Town & Country Planning Act 1990 (as amended)
Town and Country Planning (Development Management Procedure) (England) Order 2015
Approval of details reserved by condition imposed under ref LU/47/11/ relating to Condition Nos 10
surface water drainage scheme, 11 future access to & maintenance of any watercourse or culvert,
12 discharge of any flows to watercourse, 13 foul water drainage system.
Land North of Toddington Lane Littlehampton,,

Arun District Council have decided to **REFUSE details reserved by condition for the following reasons:**

The information submitted regarding Condition 11 imposed on planning permission LU/47/11: relating to the submission of arrangements for the future access to and maintenance of any watercourse or culvert (piped watercourse) crossing or abutting the site, Parcel C1 and parts of Parcels B2, B4; and C2 (LU/121/17/RES) and constitutes Phase 2 of development at the North Littlehampton Strategic Development Area (SDA), is refused and the condition is not discharged as:

Figure 3.1 Existing Lagoon and Ditch (in green) to be filled in

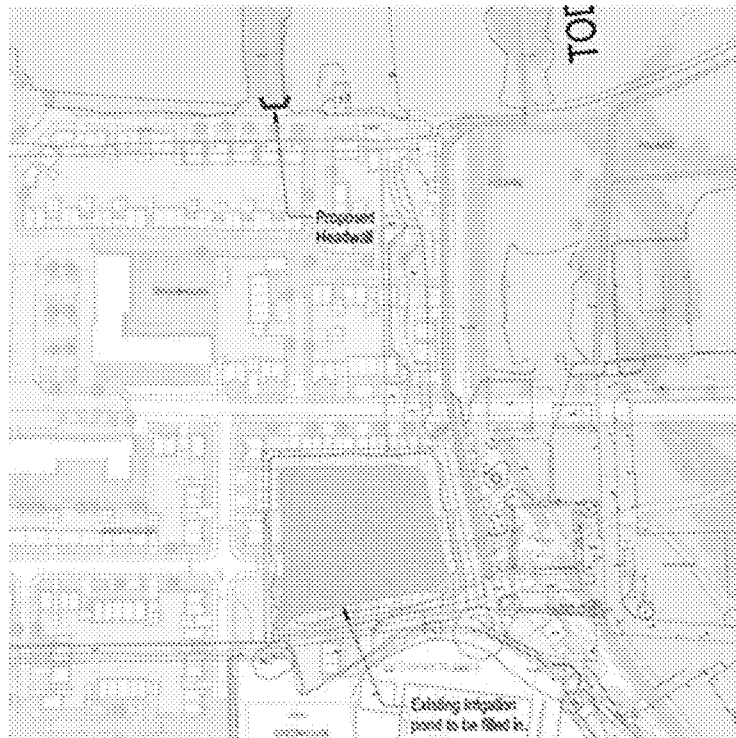
* The proposal includes infilling an IDB ditch on site, consent will be required from the Environment Agency;

* Detailed plans have not been submitted ensuring sufficient easement is provided to each of the ditches.
